Development Control  
Ribble Valley Borough Council

**Re: Planning Application 19/0861**

**Address: Green Beech Higher Commons Lane Mellor Brook Blackburn  
BB2 7PS**

**Description: Proposed first floor extension and alterations to existing bungalow to include new mono pitched single story roof to rear, flat roof entrance canopy and single story hipped roof to the side.**

GROUND FLOOR PLAN AS PROPOSED

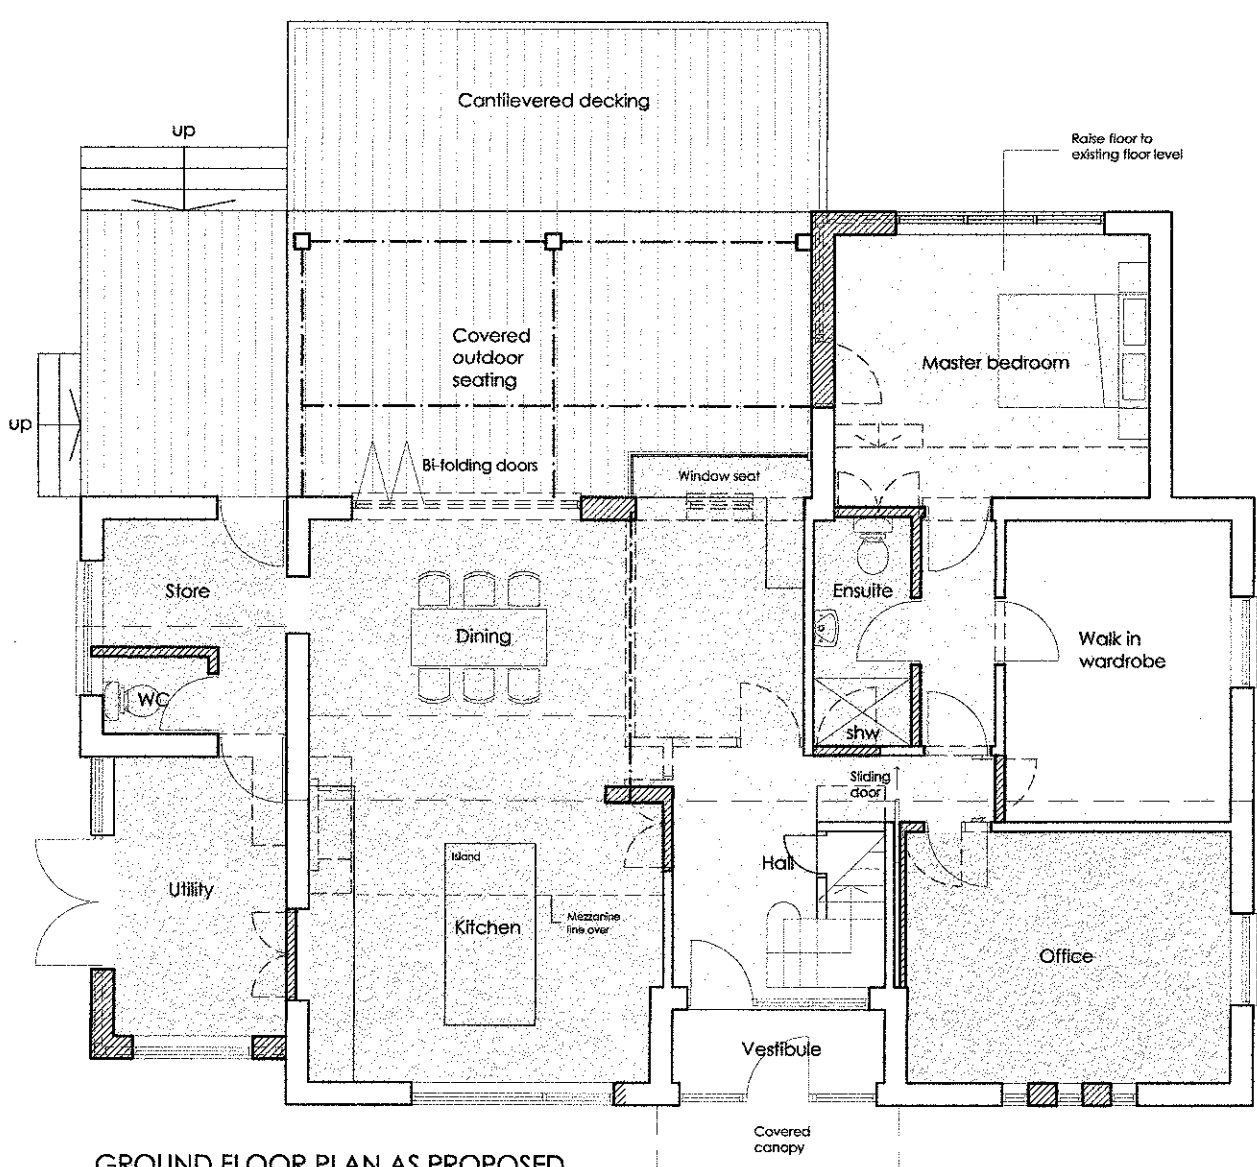
It is noted that there is an increase in the number of bedrooms which from Lancashire's Parking Standards would require the provision of 2 car parking spaces. There is no indication as to how this will be achieved. The car parking spaces should be a minimum of 2.4m x 5m, with additional space provided where there is a pedestrian access or the spaces are adjacent to walls, fences or similar obstructions that would restrict the opening of the car doors.

Following a site visit it was noted that the road is used as a route to a local primary school, therefore it would be beneficial if vehicles could enter and leave the driveway in a forward gear.

Currently the access is largely unsighted, and will require improvement with the provision of a visibility splay and the removal of visual obstructions.

1. Before the access is used for vehicular purposes, 45° visibility splays shall be provided between the highway boundary and a point measured 3m back from the nearside edge of the footway at the centre of the driveway. **Reasons:** To permit vehicles to pull clear of the carriageway when entering the site and to assist visibility.

3. Before the access is used for vehicular purposes, that part of the access extending from the highway boundary for a minimum distance of 5m into the site shall be appropriately paved in tarmacadam, concrete, block pavements, or other approved materials. **Reasons:** To prevent loose surface material from being carried on to the public highway thus causing a potential source of danger to other road users. The layout of the development shall include provisions to enable vehicles to enter and leave the highway in forward gear and such provisions shall be laid out in accordance with the approved plan and the vehicular turning space shall be laid out and be available for use before any development commences and a suitable turning area is to be maintained thereafter. **Reasons:** Vehicles reversing to and from the highway are a hazard to other road users, for residents and construction vehicles.
